SEA LINK – DEVELOPMENT CONSENT ORDER - PINS REFERENCE
EN020026

Interested Party submission by N Bridges RIBA
June 2025

- 1.1. National Grid Electricity Transmission – Sea Link Application
PINS ref. EN 020026

Document Title: LANDSCAPE CHARACTER - NATIONAL & REGIONAL

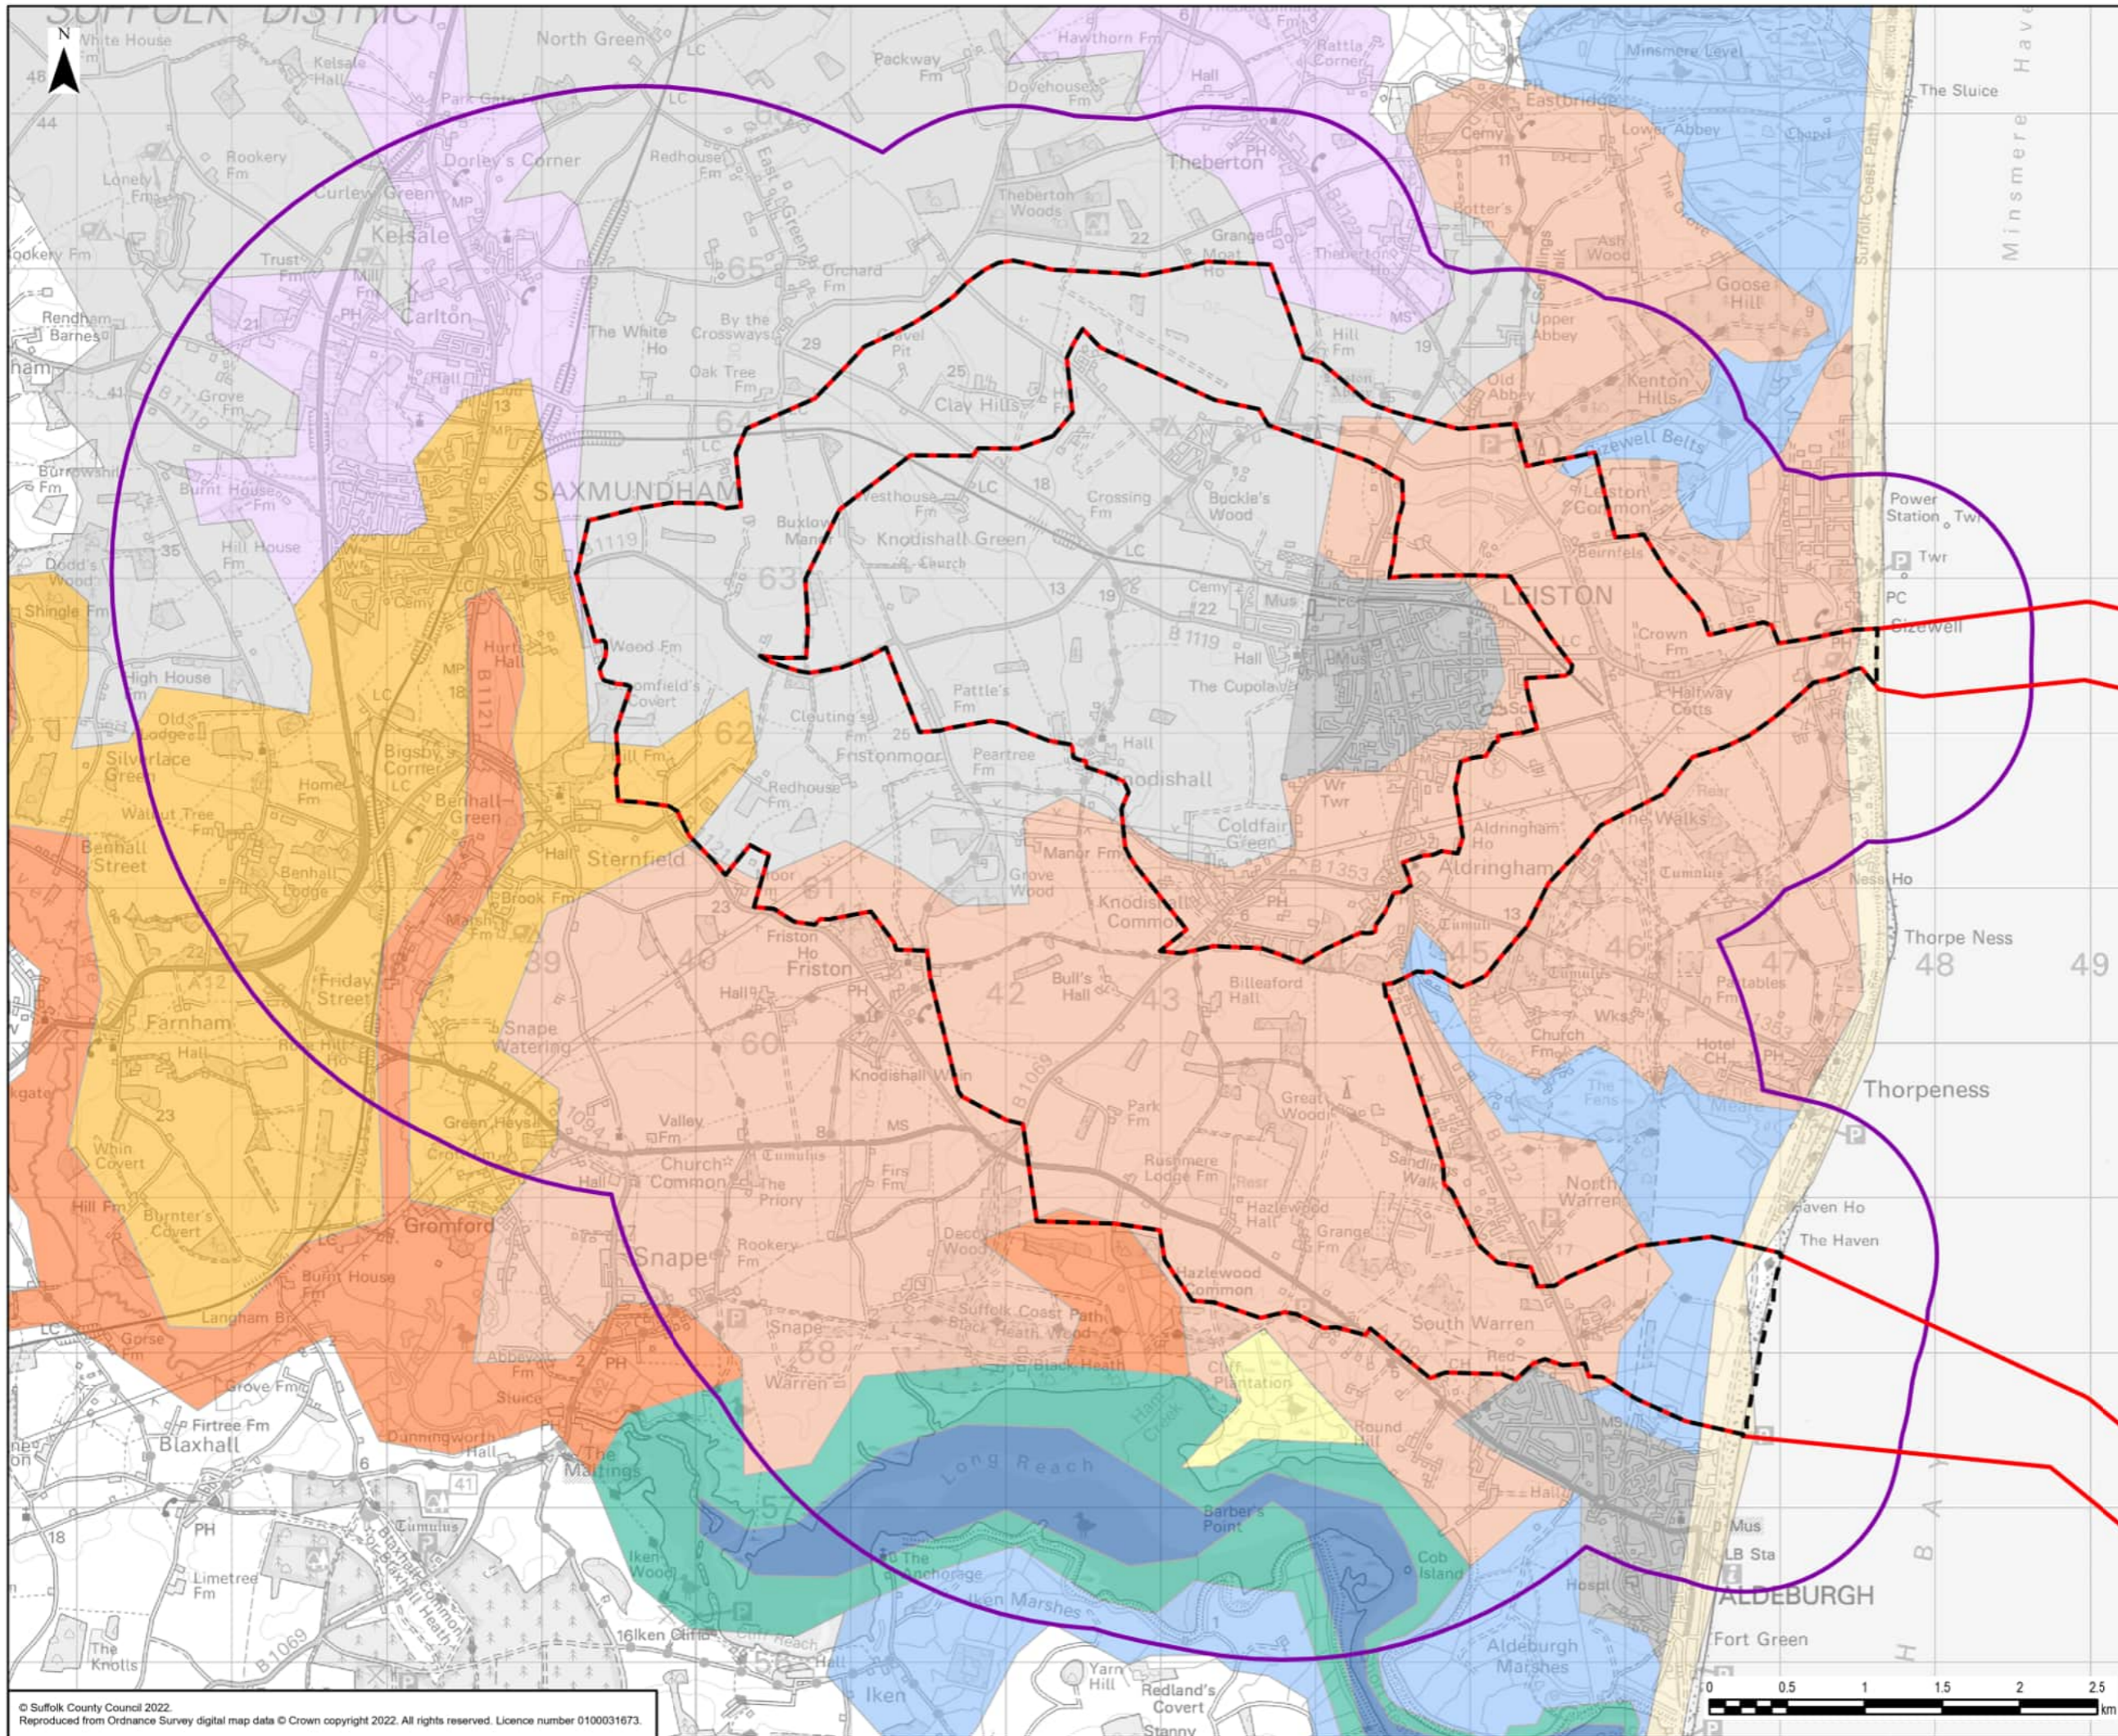
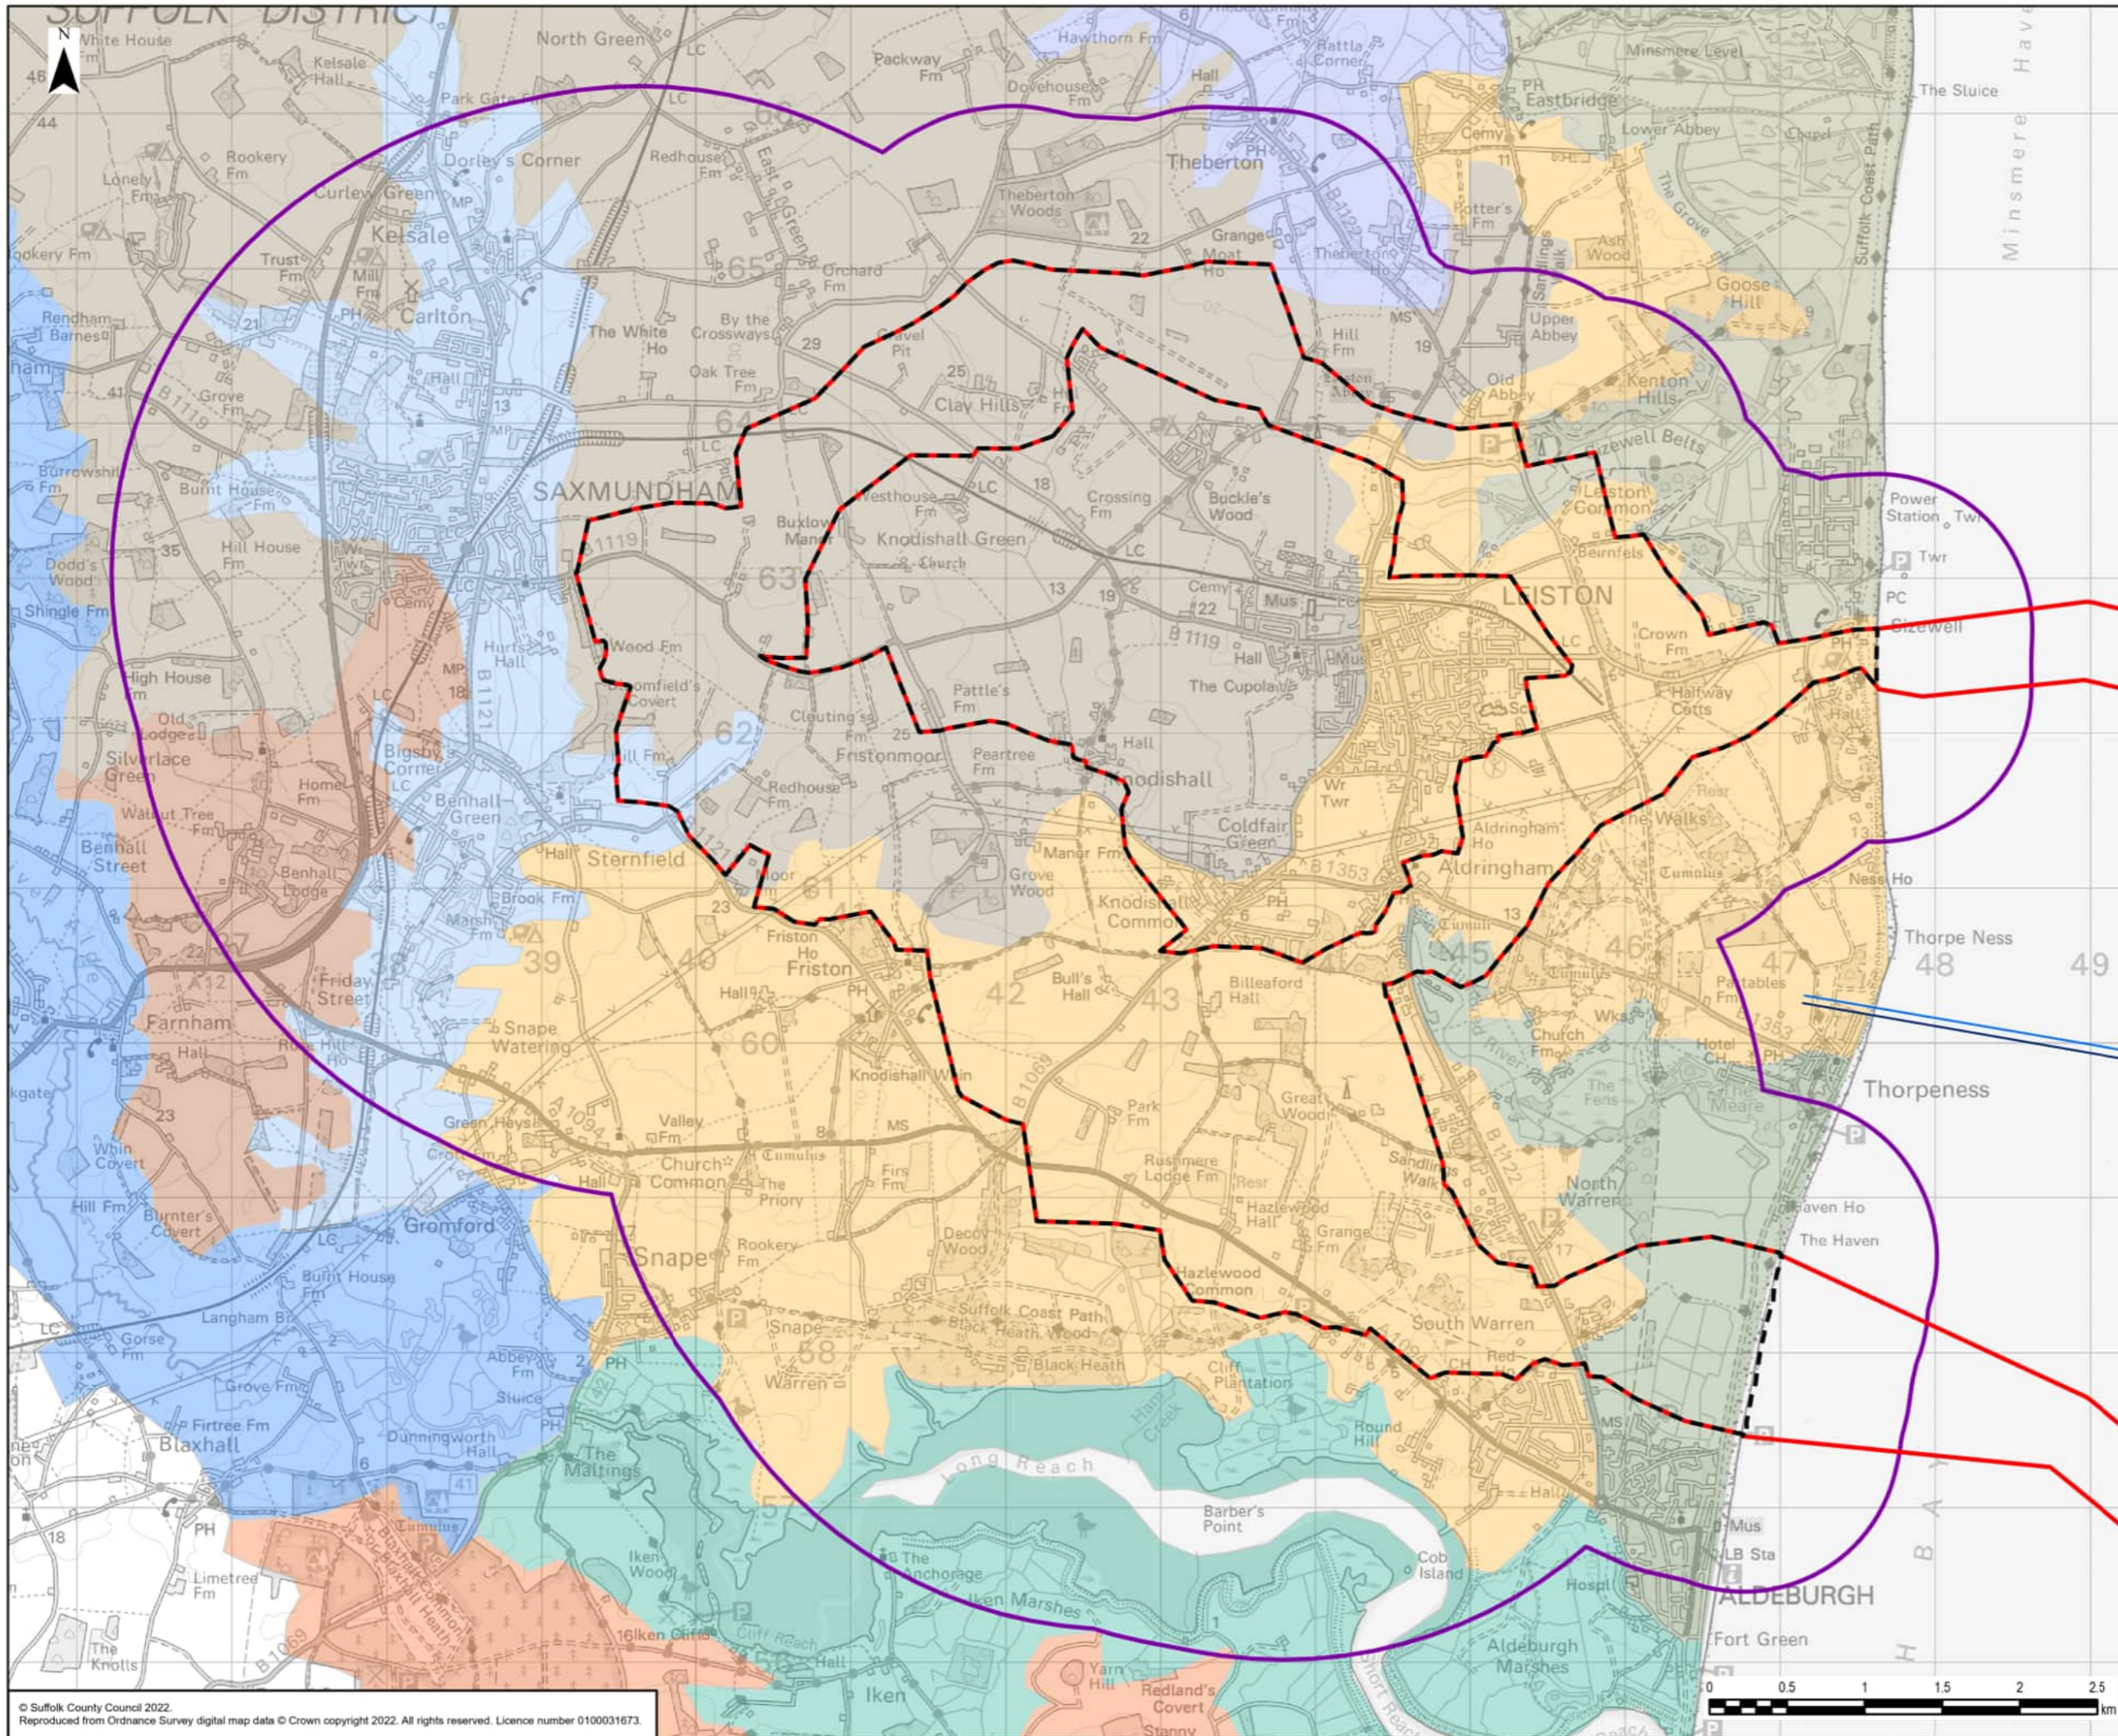
3.16. Note that the Area of Search excluded the Alde estuary as it did in the Landscape & Visual Figures (**Peir Vol. 3, Part 2, Chapter 2, Figures**). So, before the DCO Application, receptors were being excluded. The hatching of the AONB area was even excluded over the waters of the estuary, despite the AONB MP specifically stating that these were integral parts of the designated area.

- 3.26. The ExA is requested to ask NGET to include a proper assessment the Alde estuary in the Cultural Heritage and Landscape and Visual chapters of the ES. The model used to generate the ZTV plans should be run again further south to include the southern side of the Alde estuary, down to Tunstall Road on the ridge.
